**Re: Connection Reference No CDS19000532 pre-connection enquiry -  
Subject to contract | Contract denied**

**Connection for Mixed Use Development of 519 units at Former Hickey & Co LTD,  
Parkgate Street, Dublin 8.**

Irish Water has reviewed your pre-connection enquiry in relation to a Water & Wastewater connection at Former Hickey & Co LTD, Parkgate Street, Dublin 8.

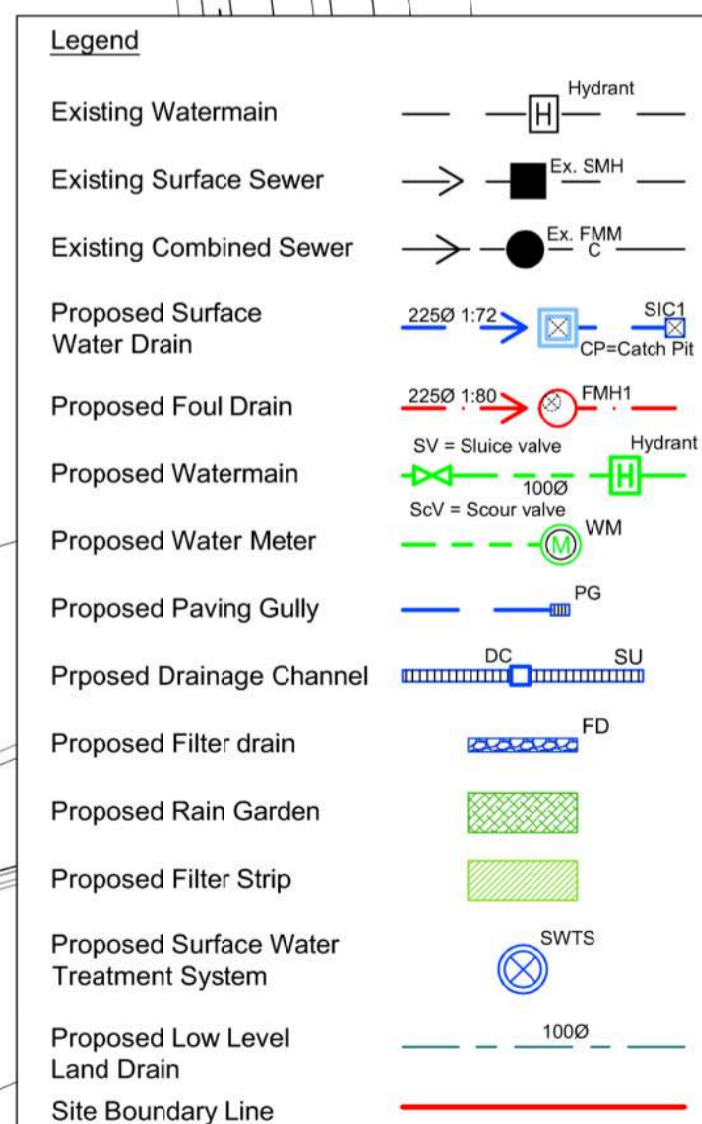
- New connection to the water network should be 150mm ID taken from the existing 6” cast iron watermain on opposite side of Parkgate Street.
- The connection should be cross-connected back into the existing 24” cast iron main running in parallel with the 6” main in Parkgate Street.

- Surface water inflow from Parkgate Street should be removed from the combined network. Minimum reduction should be equivalent to the proposed 22.4 l/s peak foul water discharge from the Development. At connection application stage you should provide evidence of the successful delivery of the Project in agreement with Dublin City Council.
